**WELWYN HATFIELD BOROUGH COUNCIL
EXECUTIVE DIRECTOR - PLANNING, PUBLIC PROTECTION AND GOVERNANCE**

Application No: 6/2019/3025/HOUSE
Location: 2 Waterworks Cottages Northaw Road East Cuffley Potters Bar
 EN6 4RB
Proposal: Proposed loft conversion with a hip to gable roof, erection of storm porch and pitched roofs to front bay windows
Officer: Ms Lucy Hale

Recommendation: Refused

12537-P008-1st

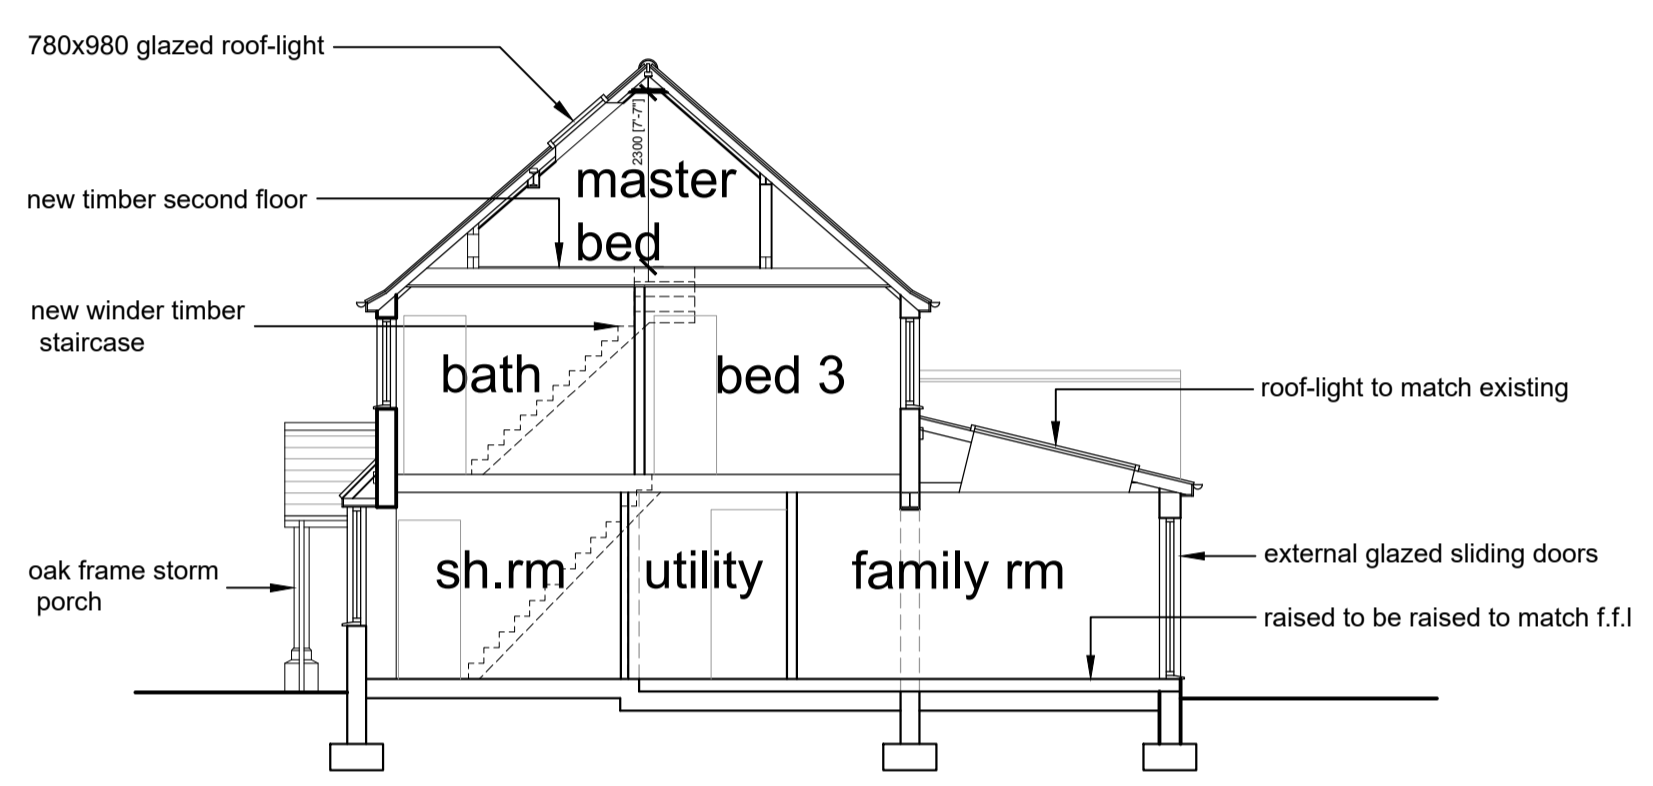
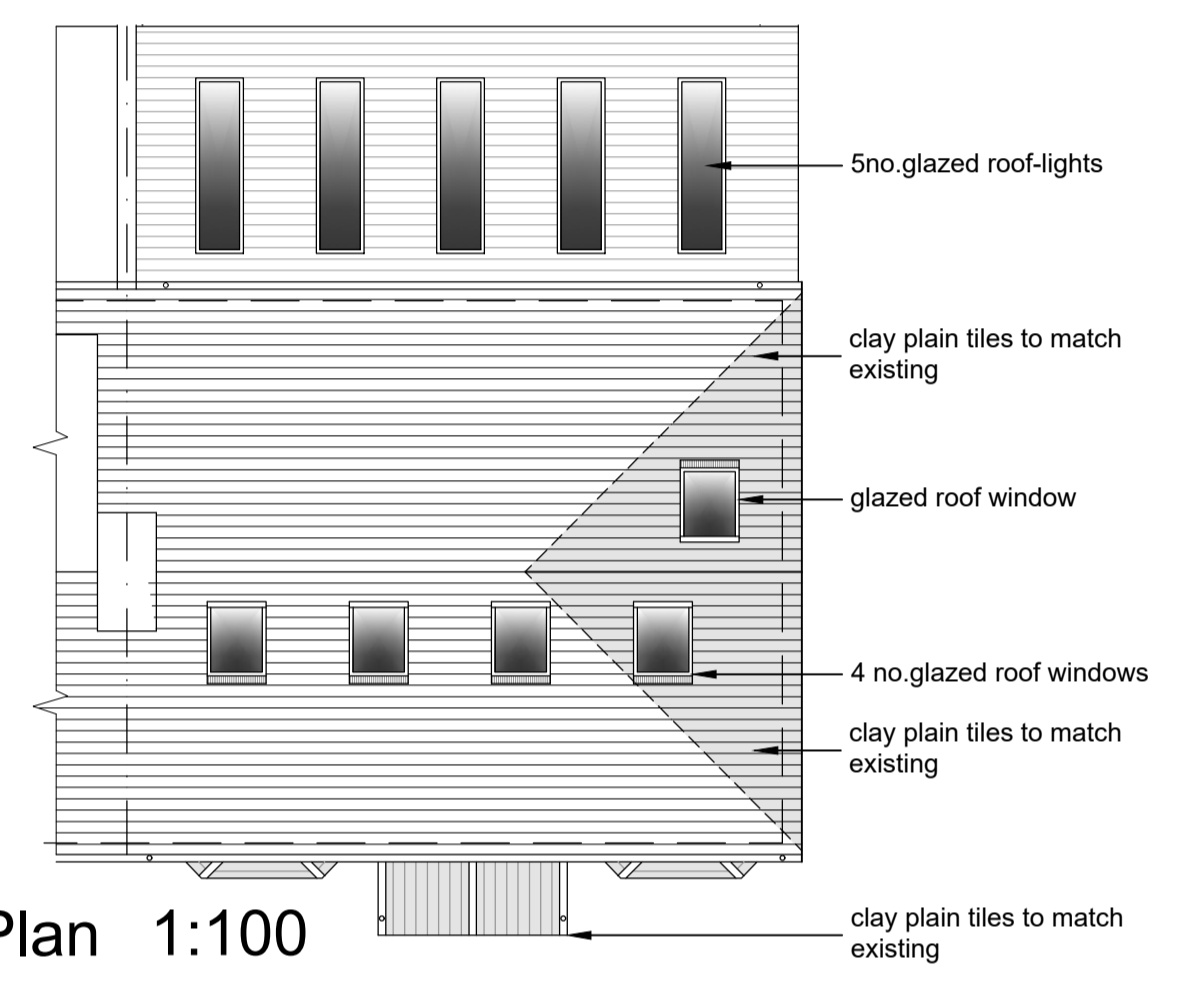
The proposal would increase the volume of the roof which could lead to the provision of habitable floor area within the roof space and the creation of an additional floor. In terms of floorspace the increase is considered to be approximately 26m², however in terms of useable floor space (headroom of 1.5m or more) it is more likely to be 15m² which equates to a 92% increase in floorspace to the original dwelling. It is acknowledged that most of the development would be contained within the existing loft space. Notwithstanding this, a hip to gable enlargement is proposed. A calculation can also be considered in terms of volume increase. The volume of the existing extension to the loft is calculated at 35m³ and the proposed addition is calculated at 19.9m³, the combined increase in volume would equate to approximately 54.9m³, which would almost double the volume of the original hipped roof.

The existing dwelling is set in approximately 5.4m from the side boundary which abuts the former site of Waterworks Complex which now features no above ground development. Although only limited views of the site are afforded from the public right of way running parallel with Hempsill Brook river, it is however adjacent to open countryside. Whilst the dwelling would not increase in footprint, the roof proposed to increase. The original dwelling was constructed with a hipped roof, measuring approximately 2.9m along the ridge from the chimney. The proposed roof would result in a gable end and a ridge length of approximately 8.6m, almost tripling the original length of the ridge.

<p>The proposal would add substantial bulk and mass to the original dwelling which would result in a disproportionate addition contrary to paragraph 89 of the NPPF. The NPPF confirms that inappropriate development is by definition harmful to the Green Belt and this is afforded substantial weight.</p> <p><i>Openness, character and appearance</i></p> <p>The NPPF confirms that inappropriate development is by definition harmful to the Green Belt. There is no definition of openness in NPPF but, in the context of the Green Belt, it is generally held to refer to freedom from, or the absence of, development. Whilst the physical presence of any above ground development would, to some extent, diminish the openness of the Green Belt regardless of whether or not it can be seen, openness also goes beyond physical presence and has a visual aspect. In the visual sense, openness is a qualitative judgement.</p> <p>The property is semi-detached with a hipped roof. The extension of a hip to gable loft conversion to the already extended property will result in a sizeable addition to the roof compared to the original built form. It is inevitable that the bulk of the dwelling would be increased by the addition to the roof which would reduce the Green Belt openness. Whilst it is acknowledged that there would be limited views of the dwelling from public vantage points as a result of its location down a private road, this does not overcome or outweigh the loss of openness.</p>

The proposed loft extension represents an inappropriate form of development within the Green Belt by reason that it would result in a disproportionate addition over and above the size of the original dwelling. Furthermore, the increased bulk and massing of the proposed development would result in a loss of openness and visual permeability of the Green Belt. Very special circumstances do not
